Re: Light Rail – Lilyfield to Dulwich Hill Extension - Application reference number: MP 10_0111

RE: Sydney Light Rail – Inner West Extension Study

SYDNEY LIGHT RAIL ENVIRONMENTAL ASSESSMENT
Application reference number: MP 10_0111

Figure 3.3 Indicative arrangement of the alternative scheme for the Marion Street crossing

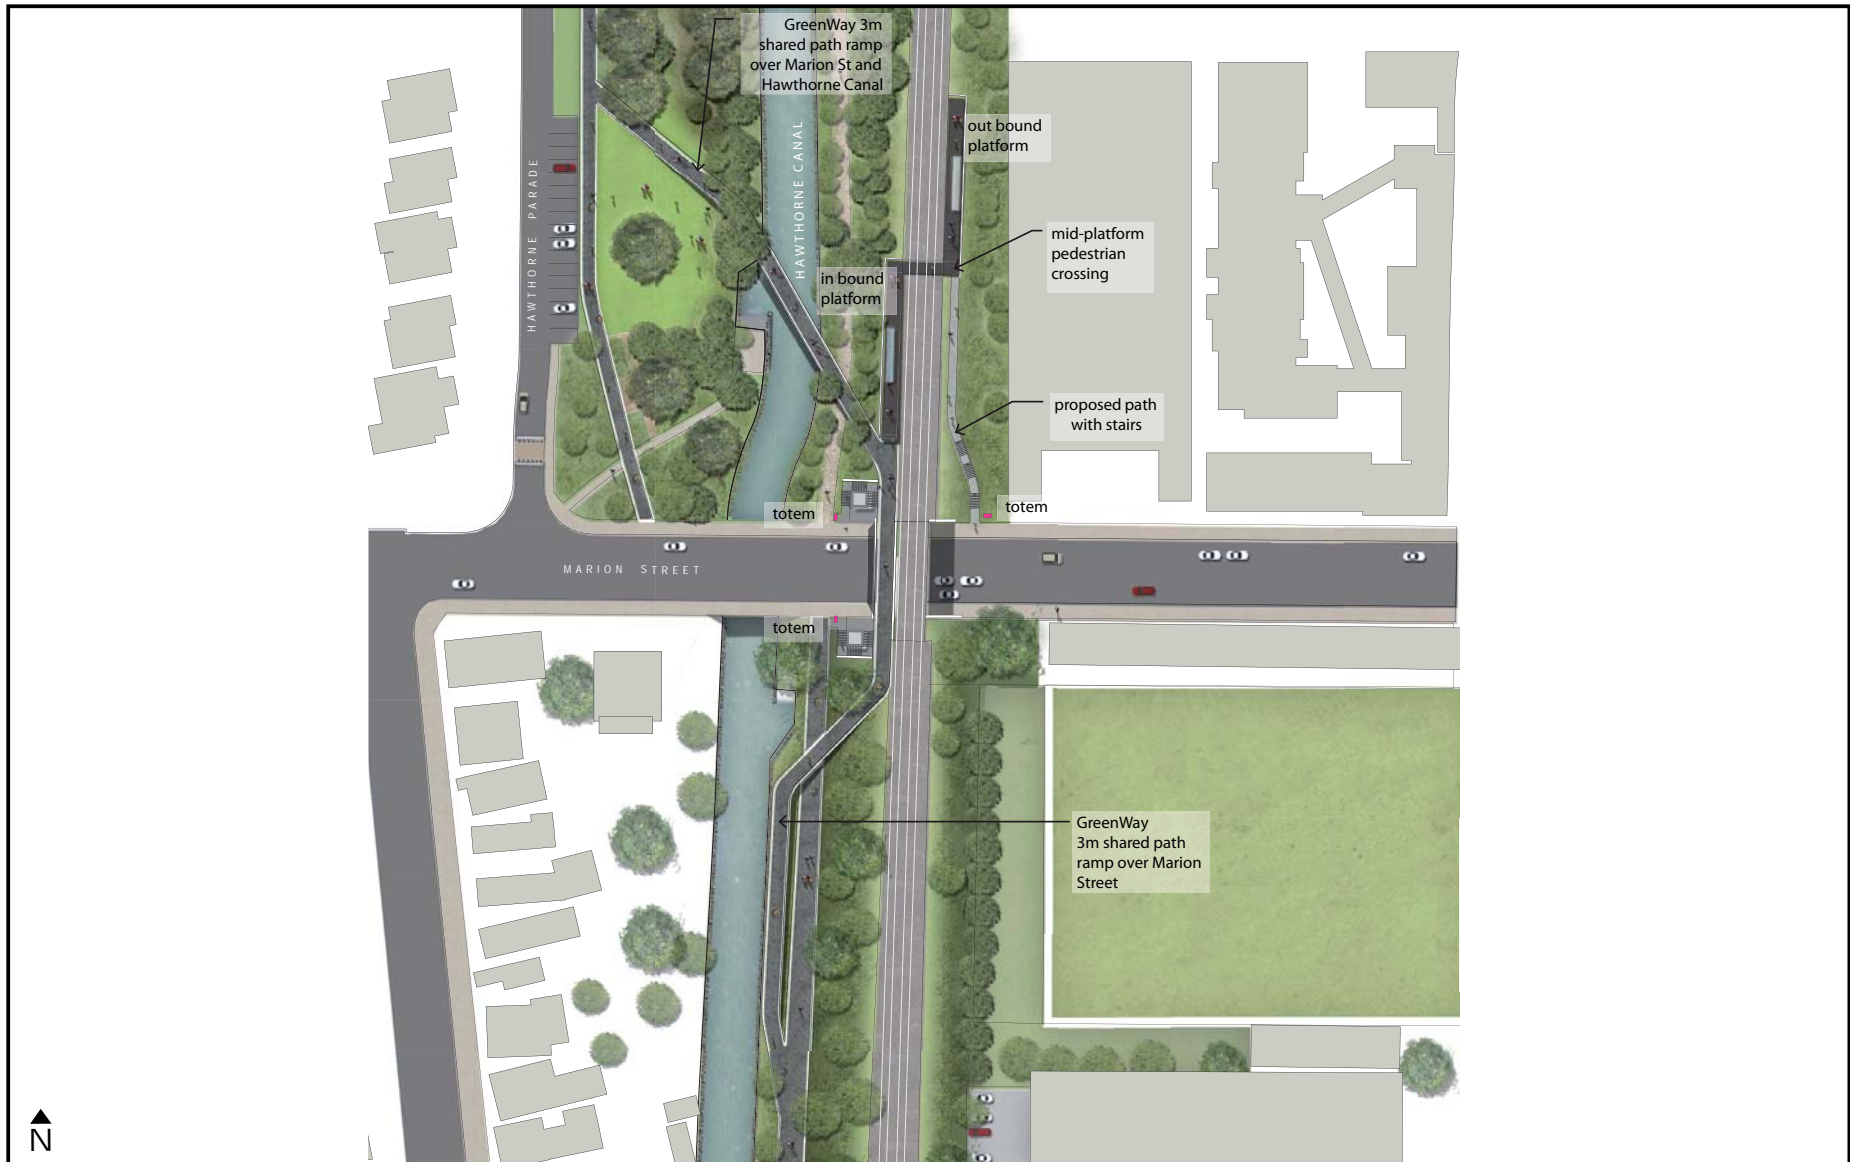
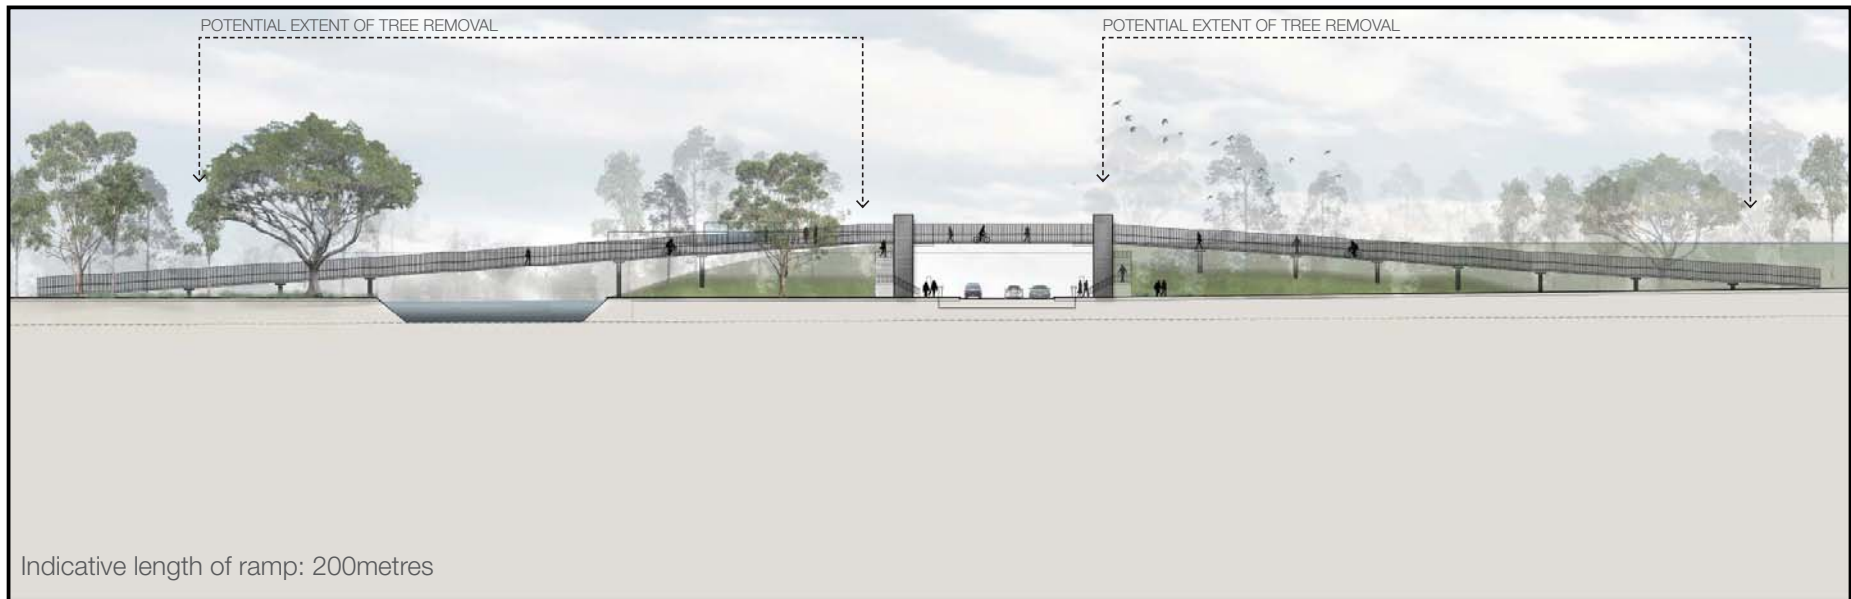
- crossing of Marion St at street level with traffic signals. This would be the only crossing of a busy road for the entire length of the GreenWay Trail, impacting on trail safety and desirability, particularly for family groups / children. There is an alternate proposal in the EA for a bridge over Marion St that is attached to the side of the rail bridge. The bridge alternative will also provide safer access to the light rail stop immediately north of Marion St for light rail passengers;

To ensure that the shared path alongside the Light Rail is safe, traffic lights should be installed on Marion Street.
